## Appeal Decision

**Appeal Ref: APP/R4408/W/24/3355298**

**Willow House, New Row Lane, Ingbirchworth, Barnsley S36 7GG**

- The appeal is made under section 78 of the Town and Country Planning Act 1990 (as amended) against a refusal to grant planning permission.
  - The appeal is made by Mr Neil Blair against the decision of Barnsley Metropolitan Borough Council.
  - The application Ref is 2023/0310.
  - The development proposed is described as: 'Erection of dwelling with access'.
-

HIGHWAY IMPROVEMENTS – SCALE 1:250

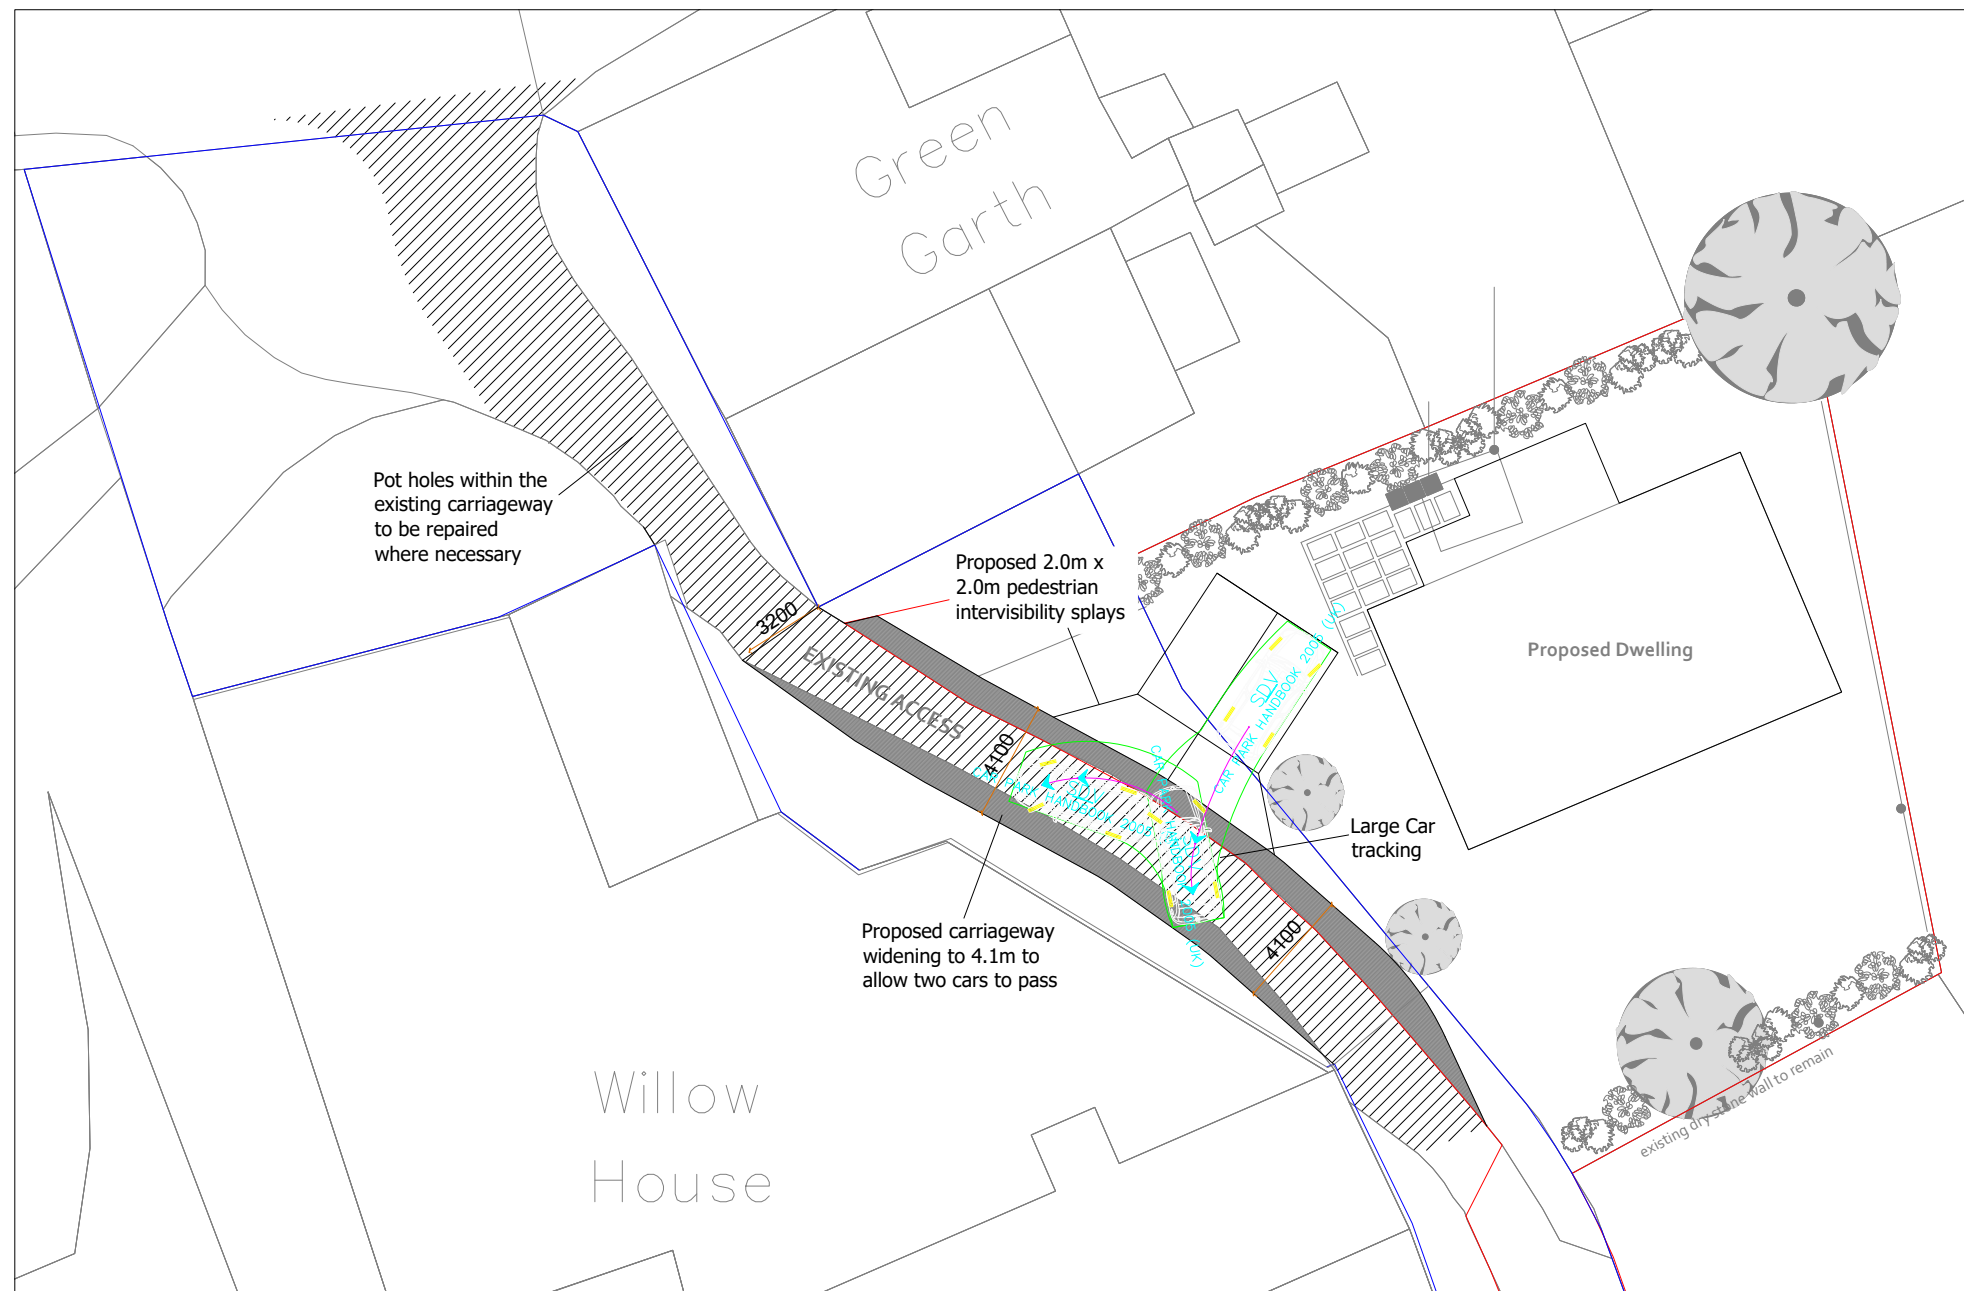
27. As part of the proposals, the carriageway would be widened along the site frontage to 4.1 metres. The Highway Improvements Drawing submitted as part of the Access Statement show that this widened section would extend for 25 metres from the site frontage in the direction of Broadfield Farm and include infilling of potholes. The width of the section of lane between New Row Lane and the appeal site would be unaltered. However, the revised width would be consistent with the minimum

28. The proposed site plan shows a parking area for two cars to the front of the dwelling, in a tandem arrangement with a turning area for delivery vehicles adjacent. However, the Highway Improvements Drawing shows two parking spaces alongside one another with no separate turning area.

30. The Highway Authority has highlighted that the scheme would not comply with the statutory government guidance 'Fire Safety: Approved Document B' where the recommended minimum road width between kerbs is 3.7 metres. The appellant has not commented on this matter; however, the appellant's Highway Improvements Drawing shows the width of the highway between Green Barn and Green Garth as being 3.2 metres. As such, whilst local residents argue this distance is narrower than stated, it is nonetheless clearly below the minimum width set out above. In any case, my own impressions on site were that the restricted width of the lane at this point, in combination with the bend in the road is likely to make access by a larger fire service vehicle difficult. There would also appear to be no space for such a vehicle to turn around. I therefore cannot be certain that the appeal site could be accessed by such an emergency vehicle if required.

T I T L E
PROPOSED ELEVATIONS

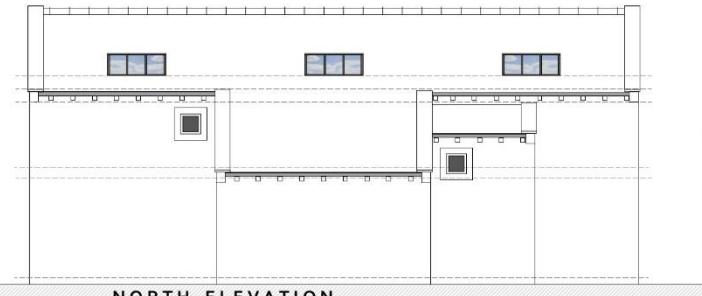
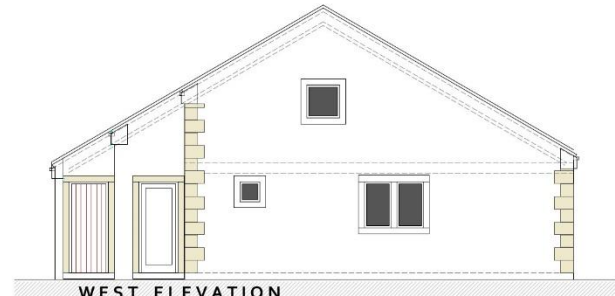
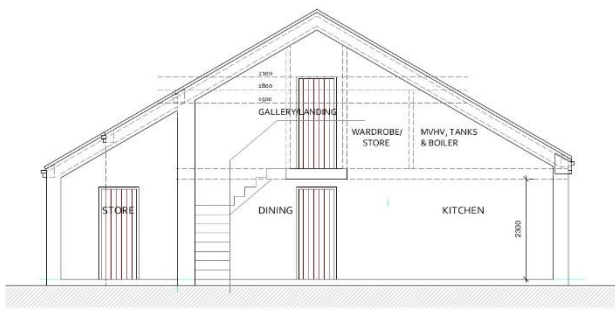
15. The footprint of the proposed dwelling would occupy much of the appeal site. Its broad, one and a half storey height gable would face the road and become a highly evident and imposing feature of the streetscene here, significantly diminishing the open, green and undeveloped nature of the appeal site. The extent of the development at the site would be highly evident from the road owing to the removal of sections of wall to form the proposed access, parking area, and the additional turning area. This, together with the road widening proposed, would result in hardsurfacing of much of this part of the site and the wide verge here, further eroding the green and undeveloped nature of the site, leading to an urbanised appearance at odds with this tranquil and historic rural setting.

48. The appellant has suggested that the proposed first floor window in the gable facing The Willows could be obscure glazed. This could be secured by a planning condition and, given the distances involved, I am satisfied that this would preserve the existing levels of privacy and avoid a significant adverse effect on the living conditions of the occupiers of The Willows.
